KITTITAS COUNTY

MEMORANDUM

TO: All Staff
FROM: Justin Turnbull, County Surveyor 
DATE: August 18, 2020
SUBJECT: County Survey Review of BL-20-00004 Bryce Philips (CDS calls this "The Pass Life")

**THE PASS LIFE AT THE VILLAGE AT THE SUMMIT, DIV. 3, PHASE 2
A PLANNED UNIT DEVELOPMENT
A PORTION OF THE SOUTH 1/2 OF SECTION 4,
TOWNSHIP 22 NORTH, RANGE 11 EAST, W.M.,
KITITAS COUNTY, WASHINGTON**

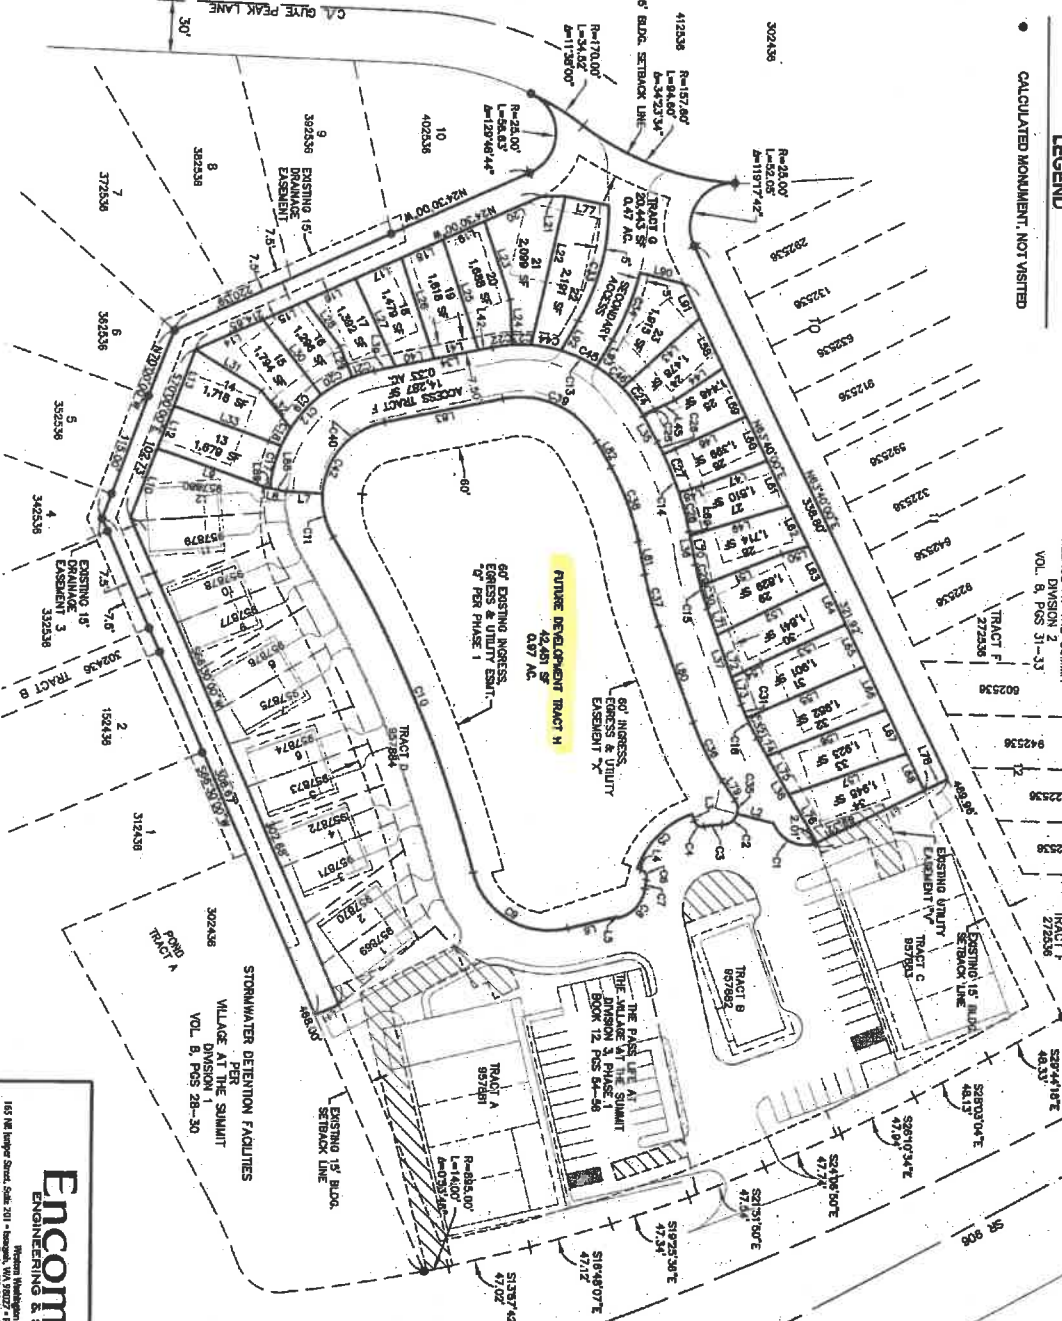
1. Note State Route 903 on the map.
2. Make following changes to legal descriptions:
 - a. Parcel 1, Paragraph 3 – consider changing "northwest" to west or westernmost.

- b. Parcel 1, Paragraph 6 – consider changing to:
 - c. "... and the beginning of a **non-tangent curve concave to the northeast, the center of said curve bears N86°23'13"E, 50.00 feet;**"

- d. Parcel 2, paragraph 12 – consider changing "northwest" to west or westernmost.
Parcel 2, paragraph 15 – consider changing to:
"... and the beginning of a **non-tangent curve concave to the northeast, the center of said curve bears N86°23'13"E, 50.00 feet;**"

- e. Parcel 2, Paragraph 27 – consider changing "northeast" to north or northernmost.
 - f. Parcel 2, paragraph 49 – consider changing "northwest to north or northeast

- g. Parcel 2, paragraph 52 – consider changing "beginning on" to "beginning of"
 - h. Parcel 3, paragraph 3 – consider changing "Northeast" to north or northernmost
